About the application

Application number: 2025/93488	
What is the application for?:	Listed Building Consent for installation of 4.19 kW Solar PV system (within a Co
Address of the site or building:	68, Wellhouse Green, Wellhouse, Huddersfield, HD7 4ET
Postcode:	HD6 4AU

EXISTING SOUTH EAST ELEVATION

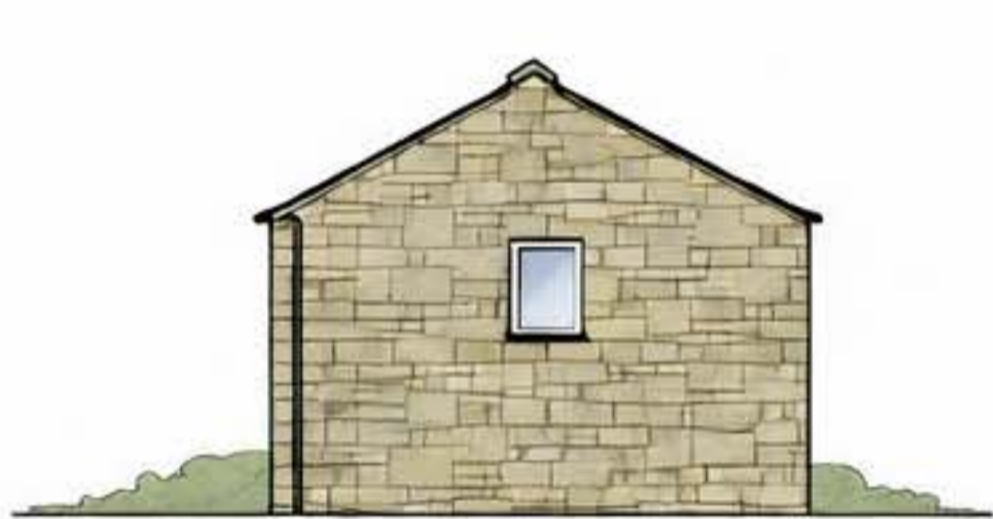
Type of comment: A general comment	
Do you wish your comments to be published on the website anonymously?	<input type="checkbox"/> Yes
<p>The submitted Grouped Plans and Elevations (id 1119969) are very confusing and bear little relation to the actual property. They would appear to be proposing the installation of the solar panels on the 'dark side' of the property ie the roof that faces North West and that attracts little to no sunlight. This seems to contradict the Application Forms (id 1119741) that refer to the "SE facing array", but that is definitely visible from the main road.</p>
